To: [Department of Planning, Industry and Environment](#)
Produced: Michele Zornitta (Associate Water Resources Engineer -WSP)
Reviewed: John Pickering (Associate Engineer - WSP)
Subject: **Waterloo Metro Quarter OSD**
SSD-10437 Southern Precinct – Response to submission comments
Date: 15 February 2021

This note has been prepared to respond to the comments dated 25 November 2020 raised by the Environment, Energy and Science Group (EES) to the Department of Planning, Industry and Environment (DPIE) public exhibition period for Waterloo Metro Quarter Over Station Development (OSD).

Specifically, this note responds to the comments for the Southern Precinct detailed SSD DA (SSD-10437). Figure 1 below represents a schematisation of Waterloo Metro Quarter OSD - areas in red identify the proposed Southern Precinct (SSD-10437).

Figure 2. Shelter areas and evacuation route – southern precinct (ground level)

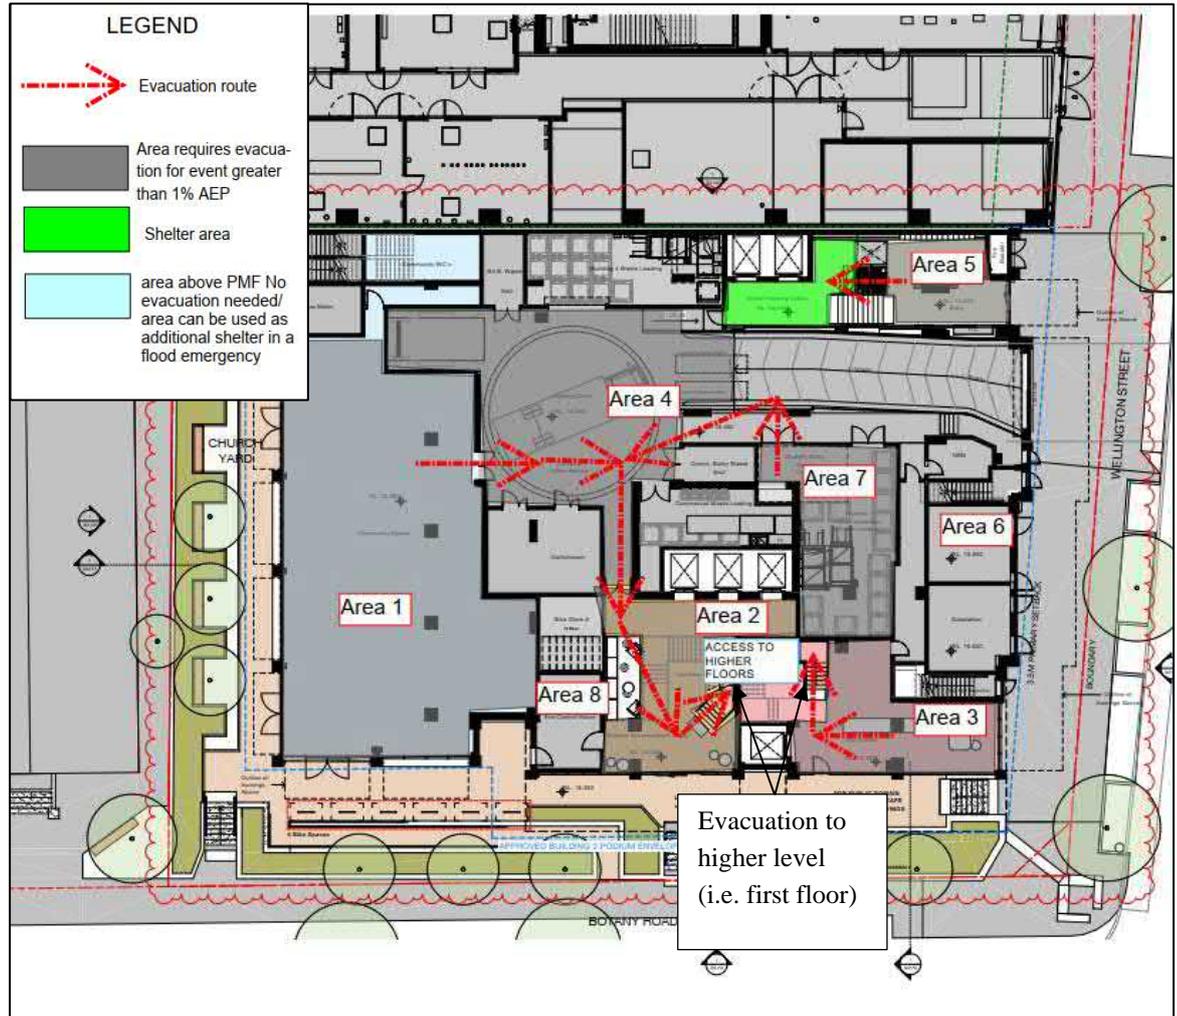
8	<p>An attempt has been made to identify areas where occupants could shelter in place. However, no consideration has been given to the number of persons at risk and whether there is enough space for these individuals in the nominated shelter areas. Any persons in external licenced seating areas, must be accounted for in emergency planning.</p>	<p>All areas in the southern building are provided with sufficient freeboard above the maximum 1% AEP flood level.</p> <p>Refer to response 7 above for further details in FPLs.</p> <p>There are no external licenced areas in the Southern Precinct.</p> <p>A flood emergency management plan will be provided at a later stage prior to occupation of the building.</p>
9	<p>Lifts and escalators may not be operational during extreme floods. It is not considered acceptable for persons coming from the basement to exit onto the street in extreme floods. Direct stair access must be provided to refuge internal to the building.</p>	<p>There are no accesses to/from the basement within the Southern Precinct.</p>

Sheet title
 General Arrangement Plan
 Ground Floor Plan

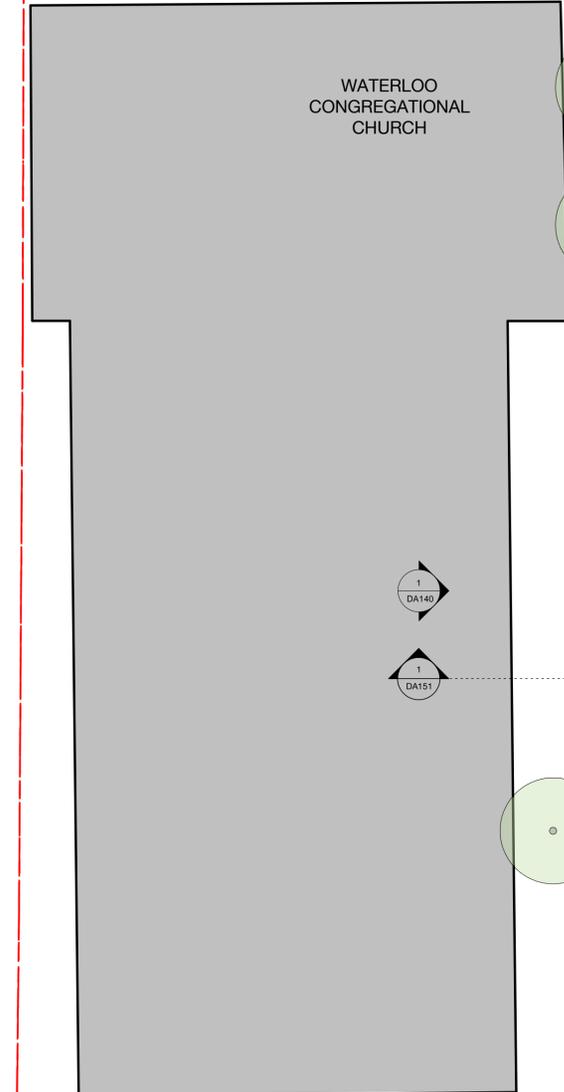
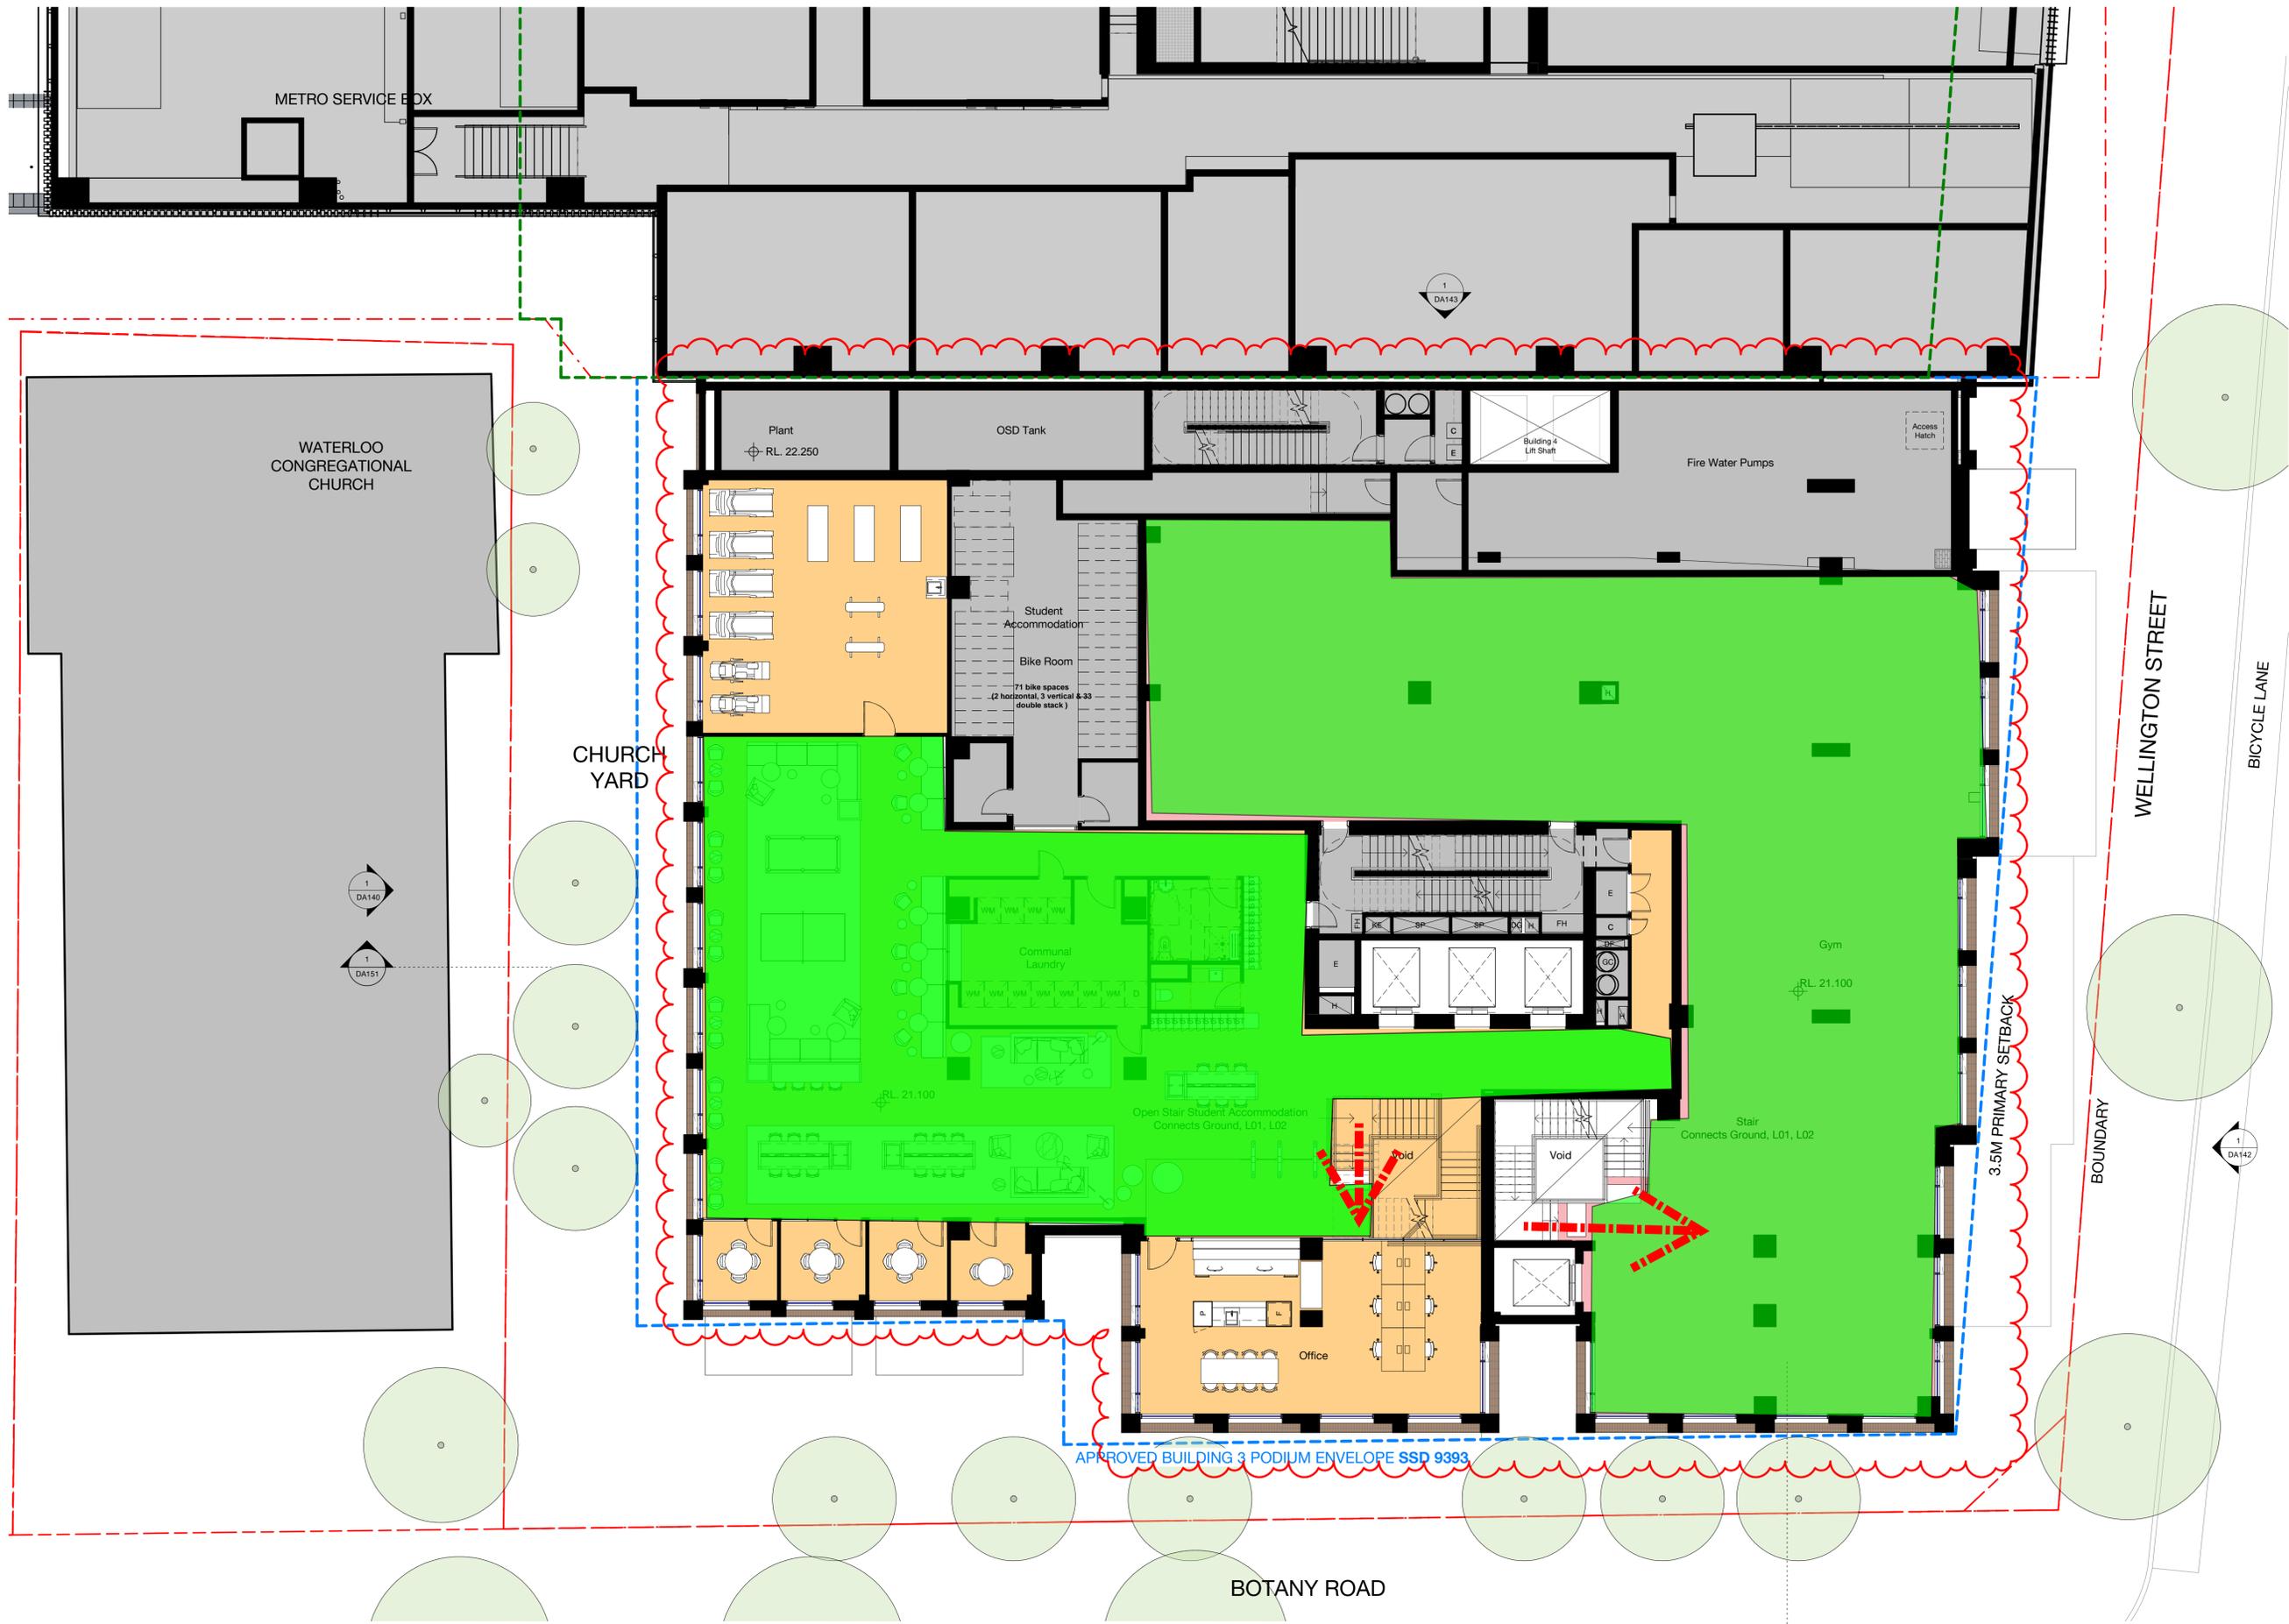
6	<p>It appears that most of the floor levels meet the requirements. The exception is Area 6, which is below the 1% AEP flood level and houses substations. The report notes that this level has been discussed with Ausgrid, however no indication is given that Ausgrid accepted this lesser level of flood protection or what the predicted flood frequency would be. Without any such assurance, EES recommends that the floor level be raised to comply with the requirements. Areas 1-4, 7 and 8 are above the 1% AEP flood level plus 0.5m freeboard, but approximately 100mm below the PMF level. Area 5 rises above the PMF level beyond a lower</p> <p>As indicated in the report floor level for Area 6 has been discussed and accepted in principle by Ausgrid.</p> <p>We believe that Ausgrid's acceptance of the proposed floor level for Area 6 is a sufficient justification for the EES reviewer. Relevant correspondence with Ausgrid is attached to this response.</p> <p>Furthermore, the location of the Wellington St substation was the subject of considerable discussion with the Design Review Panel. Numerous options for the location of the substation were assessed by the design team,</p>

entry area. Area 9 is above the 1% AEP flood level.	and in after consultation with the DRP, the DA design was endorsed (item 8.06)
Flood risk for the development – Residual Risk and Emergency Management		
7	<p>While it has been asserted, that “Safe refuge can be provided within the proposed development”, this has not been demonstrated. There are several issues regarding residual risk that have not been addressed and require amendments to the design. It is recommended that the proponent engage a suitably qualified and experienced professional to develop an appropriate strategy for flood emergency management. The Alexandra Canal Floodplain Risk Management Study and Plan should be considered along with all relevant emergency management documents by the SES.</p> <p>The discussion regarding timing of flooding in relation to evacuation has not demonstrated an understanding of the principles involved and is not consistent with current available guidelines. Before the proposal moves to the next stage, a proper assessment of the flood behaviour as it relates to emergency management is required, together with the development of a strategy for flood emergency management. Detailed information on the timing/duration of extreme events should be considered and presented. Shorter and longer durations should be considered for emergency planning, not only the duration that generates the peak flood level.</p>	<p>Floor levels proposed for the Southern Precinct provide flood protection in a flood emergency; no evacuation from the building would be required as safe refuge is provided within the development.</p> <p>The following arguments should be considered in the determination of the flood risk and residual risk for the development:</p> <p>Area 1 (community use): area 1 is designed to be at 1%AEP + 706 mm freeboard flood level.</p> <p>In an extreme flood event (i.e. PMF) water depth is expected to be up to 18 cm. As such, flood risk in a PMF event is considered low. According to ARR 2019 guidelines flood hazard in Area 1 in a PMF event is classified as H1 – generally safe for people, vehicles and buildings.</p> <p>No evacuation is deemed necessary for occupants of Area 1 as sufficient flood protection (i.e. 1%AEP+706 mm freeboard) is provided within the area.</p> <p>It is not possible for Area 1 to have floor levels above the PMF without compromising street activation.</p> <p>In a PMF event occupants of area 1 are safe and not in danger.</p> <p>Area 2 (student accommodation lobby): area 2 is designed to be at 1% AEP + 706 mm freeboard flood level. In an extreme flood event (i.e. PMF) water depth is expected to be up to 18 cm. Access to higher floors is also possible within Area 2. Flood risk is considered low. As per ARR 2019 guidelines flood hazard in Area 2 during a PMF flood event is classified as H1</p>
